OUT18/10034

**Mulwala Solar Farm (SSD 9039)  
EIS Exhibition**

Alison Collaros  
A/Manager, Assessment Advice  
**Lands and Water - Strategy and Policy**  
31 July 2018

Figure 8
Groundwater Borehole Locations
Mulwala Solar Farm

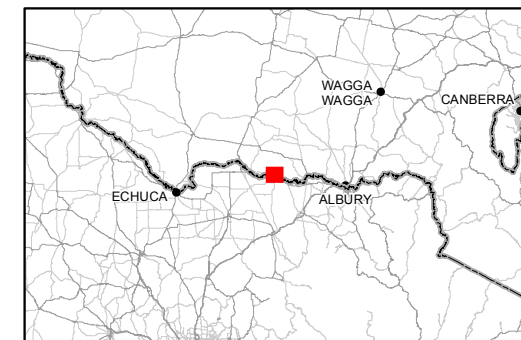
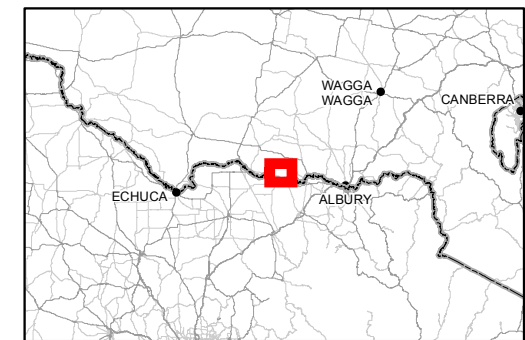
- Confirm that a secure water supply is available for the project, including confirmation of which bores and dams are proposed to be used to supply water for the project and confirmation that they are appropriately licensed for the purpose.
- Where water supply works are to be accessed from landholders and/or local water authorities it is recommended confirmation be obtained of the ability to access these supplies prior to project determination.

There is uncertainty as to the sources of water supply and the current and required licensing for the project.

The EIS details a range of potential water sources to supply the 10ML construction water demands and the 0.5ML/year operational demands for the project, including existing groundwater bores, water tankers and temporary dams. The EIS also makes reference to six small ground tank dams located within the project area.

It is unclear if these are the 'temporary dams' referred to as potential water sources. Further information is required to confirm the proposed water sources and their licence status, and the impacts of extracting water from these water sources.
